**Just Transition Wakefield. Detailed submission, 22/02/2023.**

**Drax Bioenergy with Carbon Capture and Storage, PINS Reference: EN01012**

0.1 I am writing on behalf of Just Transition Wakefield to comment in detail on the planning application from Drax Power to retrofit carbon capture and storage (CCS) facilities to up to two biomass generator units. This submission builds on the initial relevant representation we made in the autumn and responds to points made and responses to questions during Issue Specific Hearing 1.

PROJECT No: 70072063	DRAWING No: 70072063-FCA-1	REV: A
--------------------------------	-------------------------------	------------------

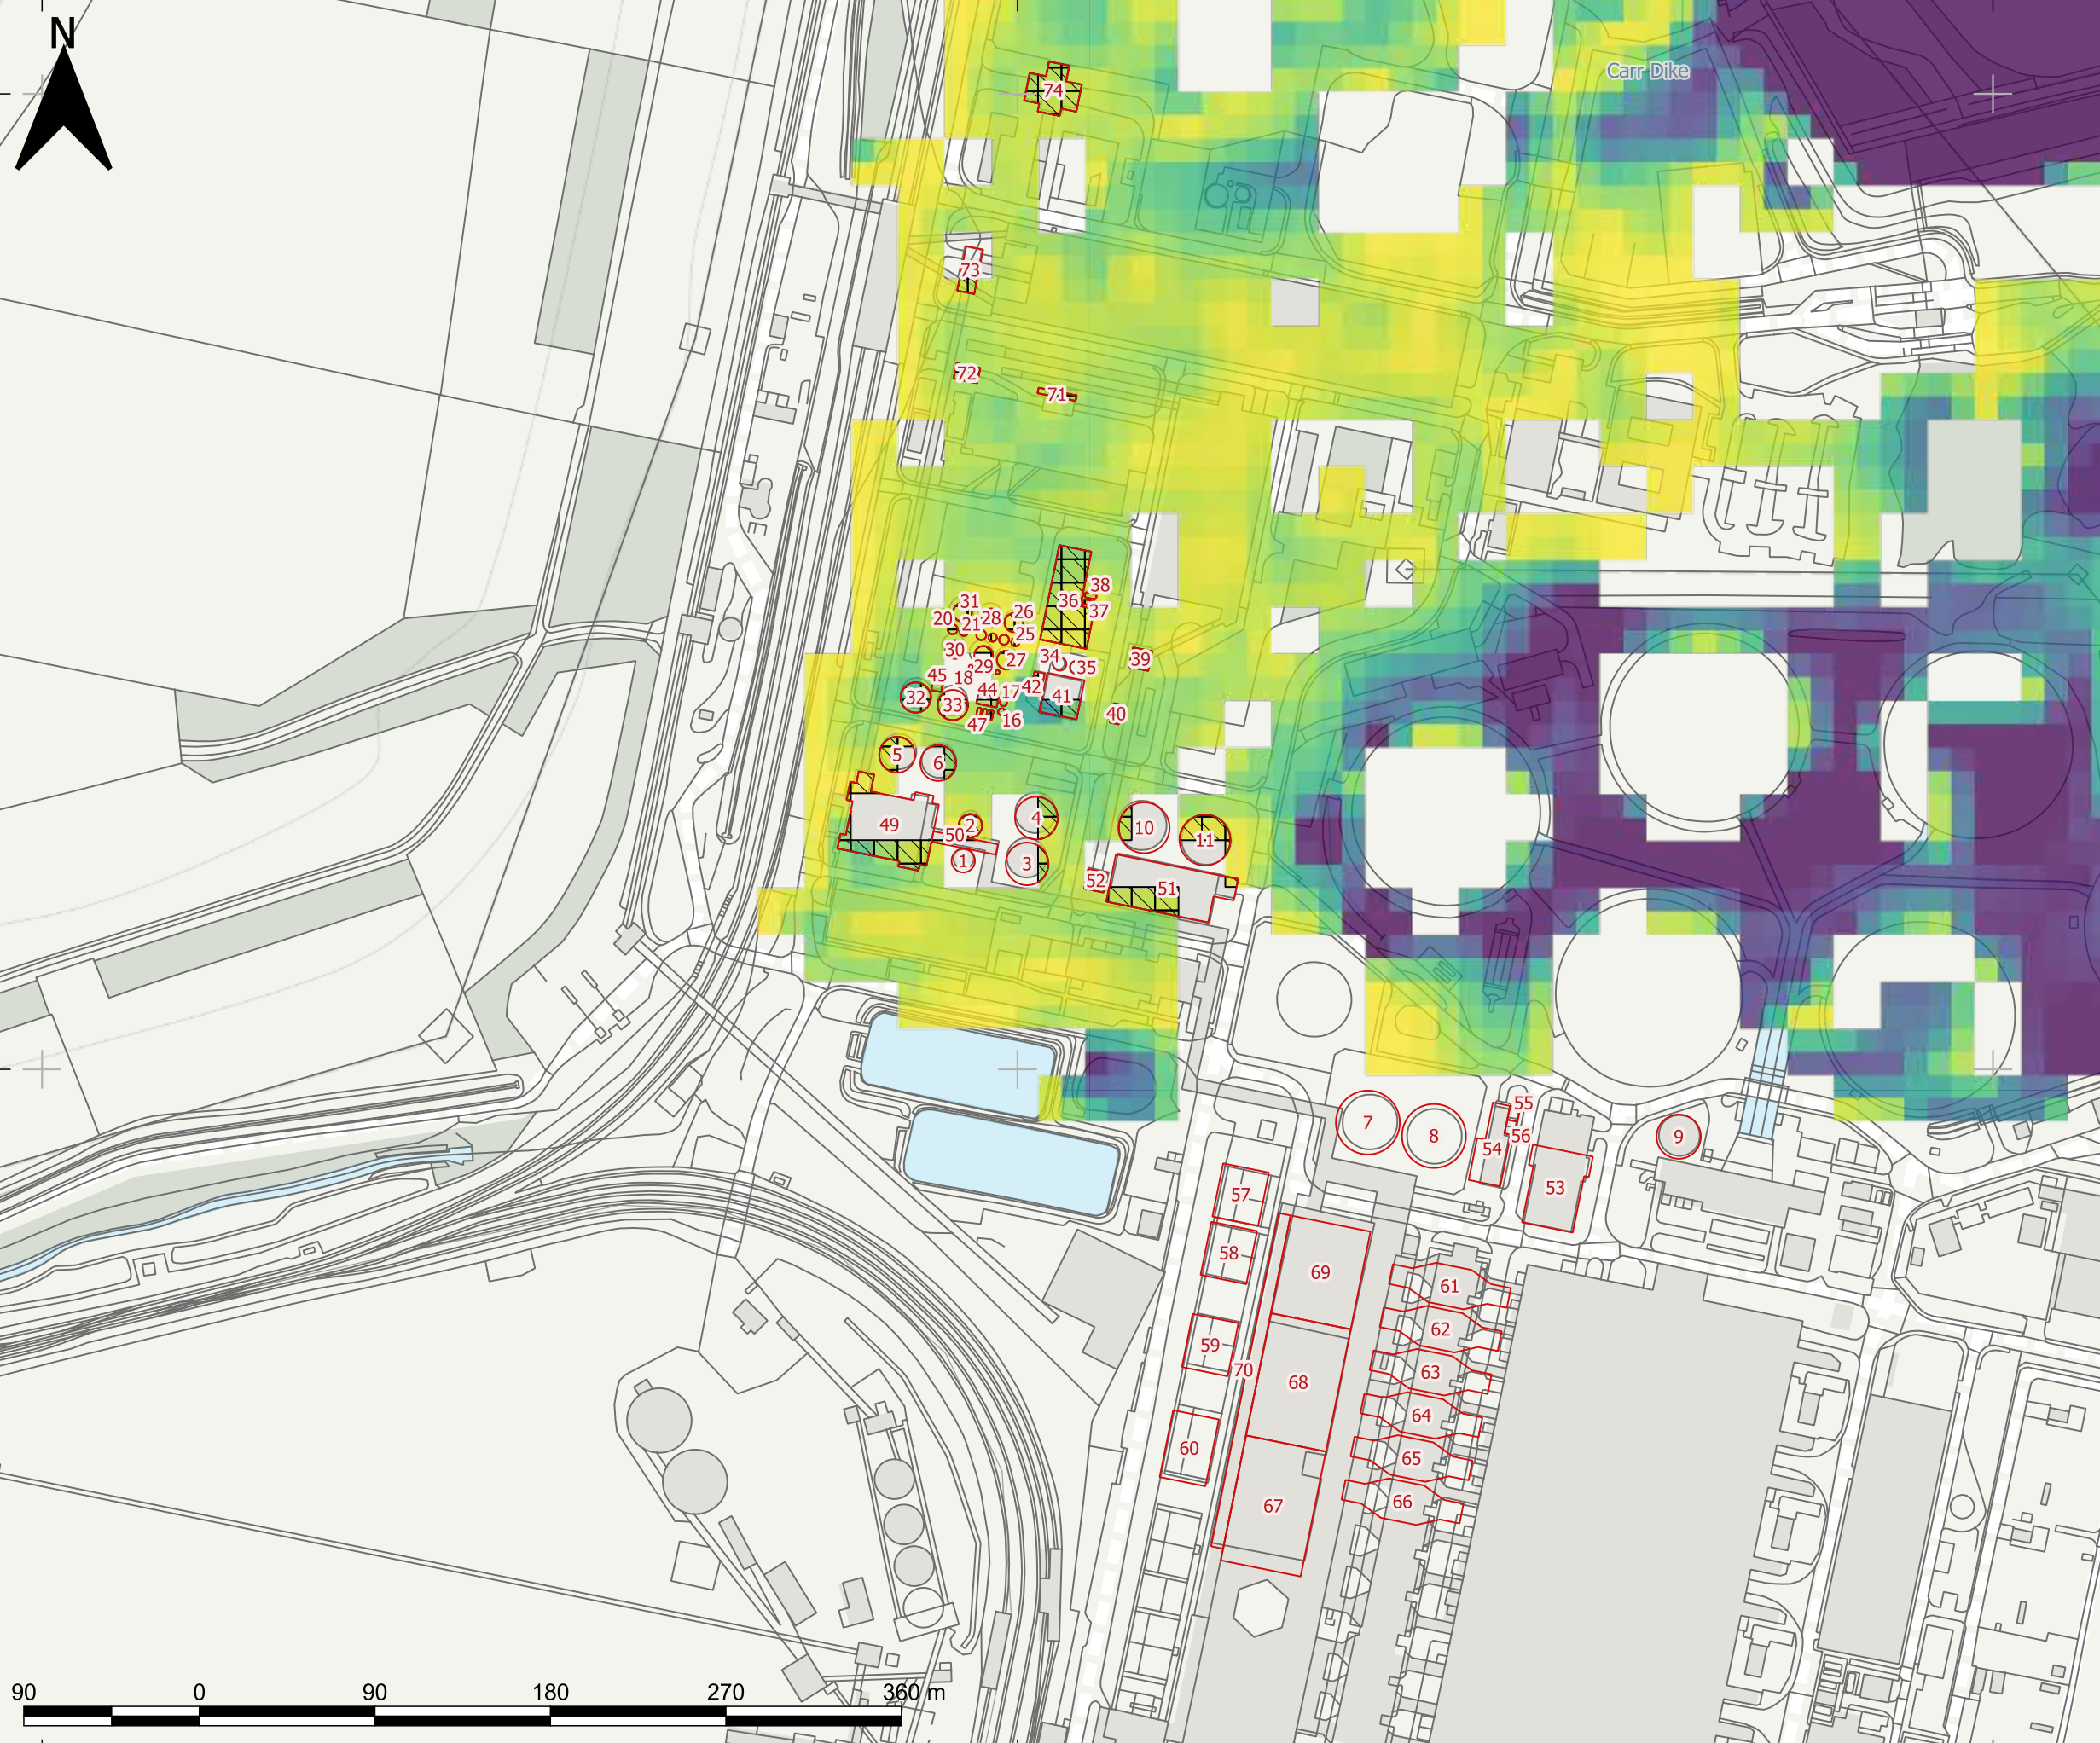
3.1 On page 21 of the Flood Risk Assessment Document (Appendix 12.1, Document Reference Number: 6.3.12.1 ) it is stated *“there are no records of historical flooding in the area of Drax Power Station or within the carbon capture location boundary”*. We wish to challenge the flood risk assessment on the grounds that:

- Drax and the surrounding area is a known area of flood risk with flooding becoming more frequent. This is verified by residents and historic local press reports;
- The flood risk assessment needs to be re-evaluated to take into account the latest Climate Change Risk Assessment (CCRA 2022);
- Drax’s flood risk assessment fails to consider risks to the rail supply network which we believe is a major omission as the rail freight network crosses both the Aire and the Ouse flood plains.
